DRB Application No.: 09DRB-70145 Project # 1003698  
 Project Name: Brownell & Lail's Highland Addition  
 Agent: \_\_\_\_\_ Phone No.: \_\_\_\_\_

5. **Project# 1003698**  
09DRB-70145 MINOR - PRELIMINARY/  
FINAL PLAT APPROVAL

**RE: Lots 10-12, Block 18, Brownwell & Lail's Highland Addition**

THE PURPOSE OF THIS PLAT IS TO COMBINE THE NORTH 1/3 OF LOTS 10, 11 AND 12 INTO 2 LOTS AND GRANT ANY EASEMENTS AS SHOWN.

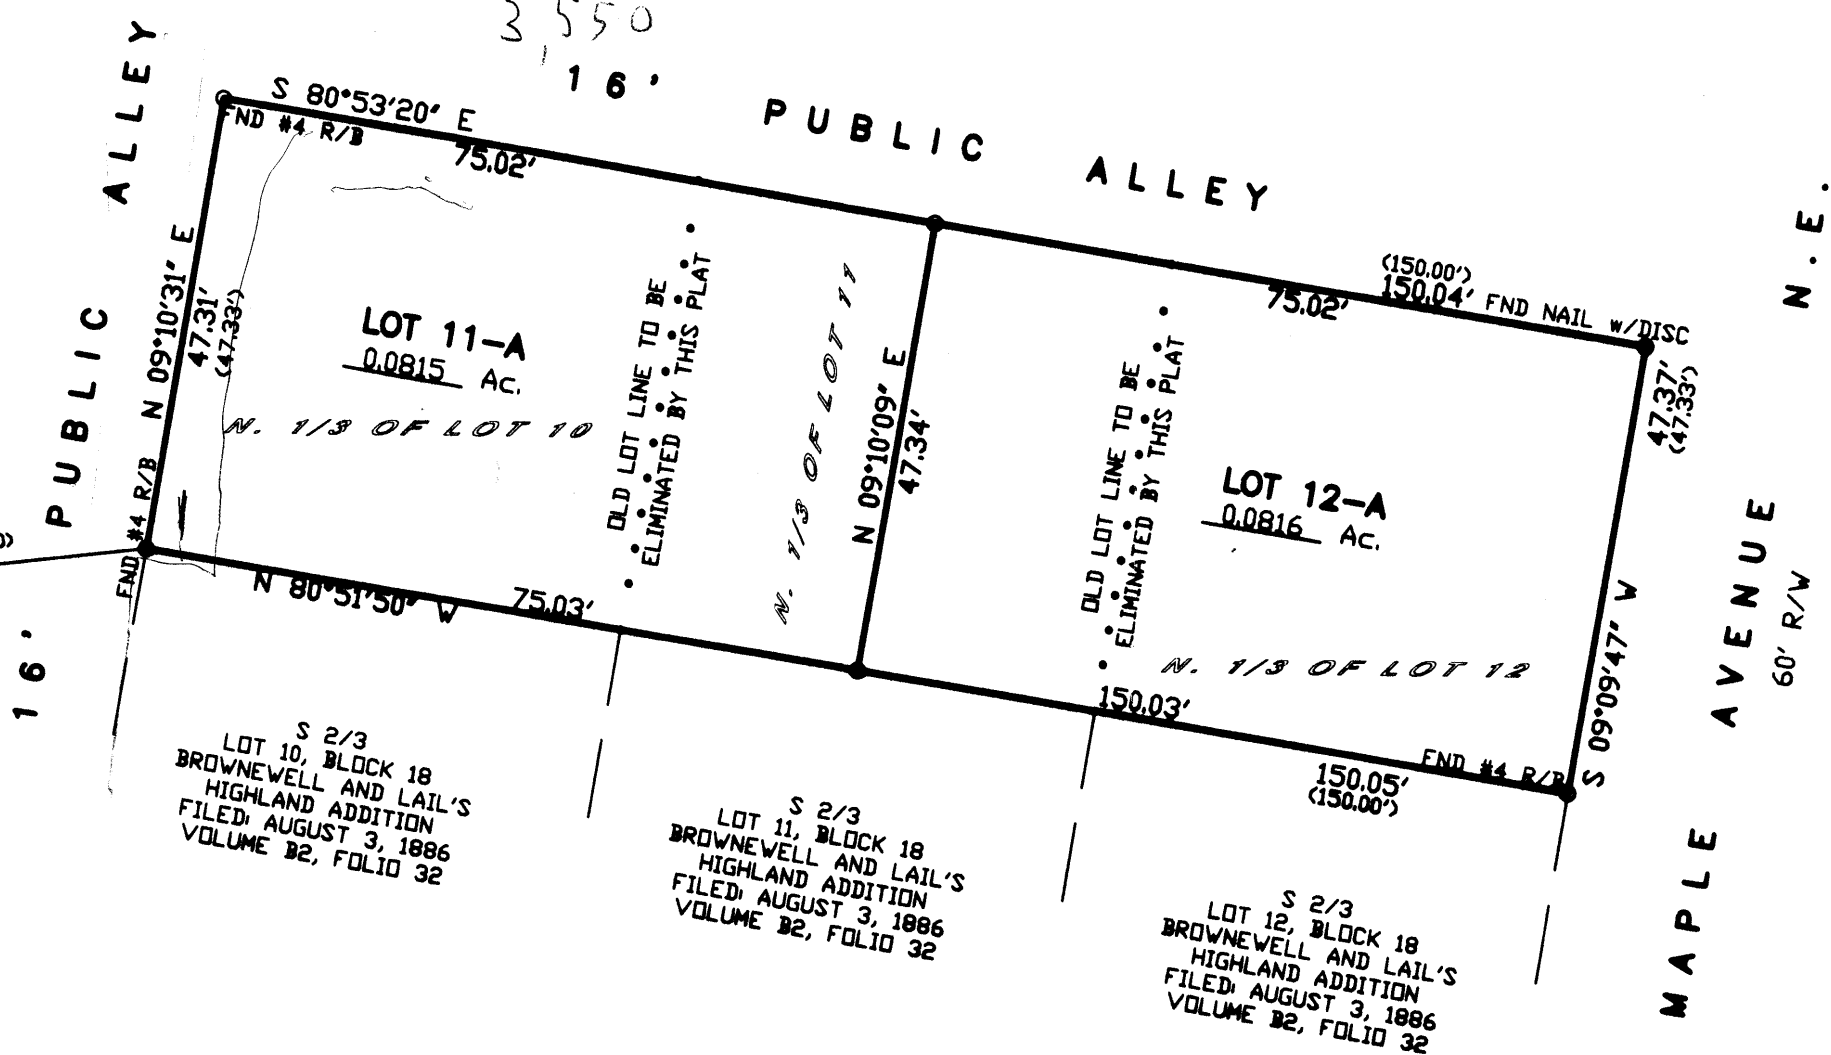
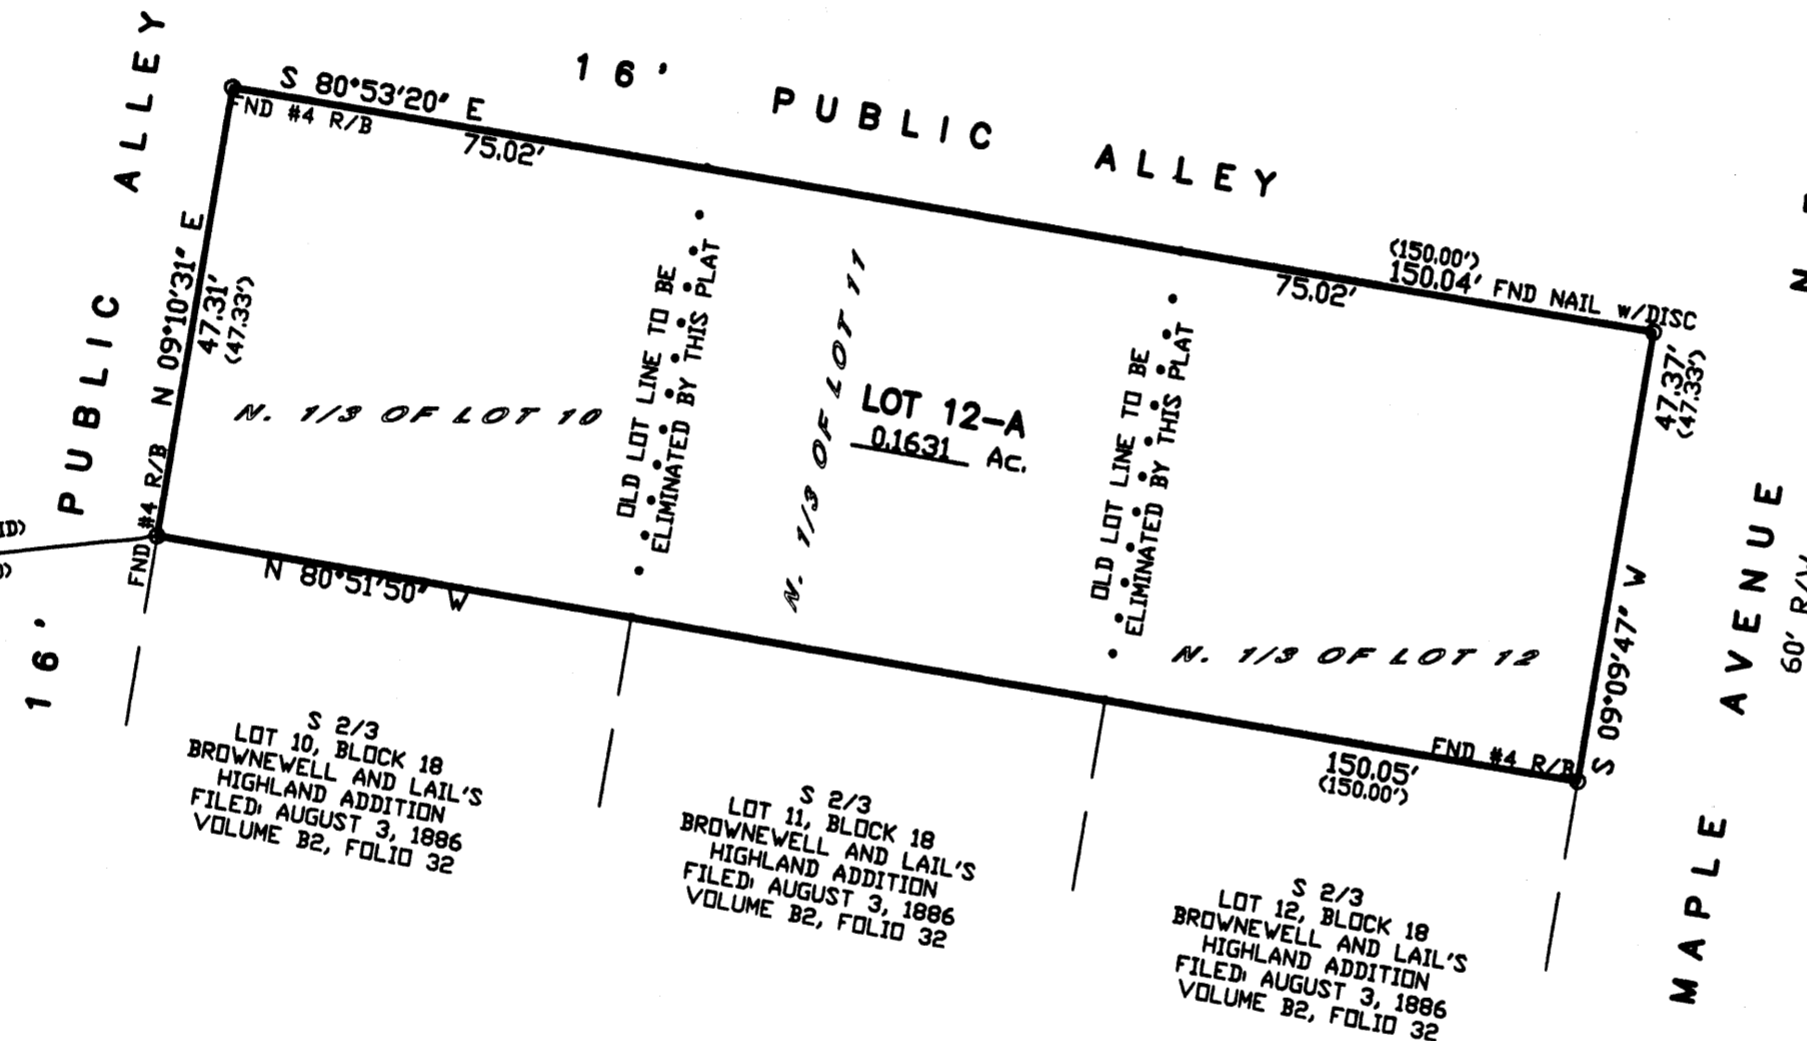
A brief review of the plan did not indicate that primary access is allowed from an alley; typically a lot must front a street, or have access to a street via an access easement. In other words, the proposed alley lot does not have a front lot line.

The right of way at the intersection of two alleyways requires a radius of 20 feet. The right of way at the intersection of a local roadway and an alley requires a radius of 20 feet. Since Lot 11A will be taking sole access from the alleyways, the alleys must be 20 feet wide and paved. Infrastructure will be required. Right of way dedication will be required.

1. There are no water/sewer lines in the alleys to serve the proposed 2 lots in the rear. Lines are available in Maple. This would require private service line easements across the front lot with water meters placed in Maple. One rear lot could take sewer service at the dead end sewer line manhole at the alley intersections at the NW corner of site.
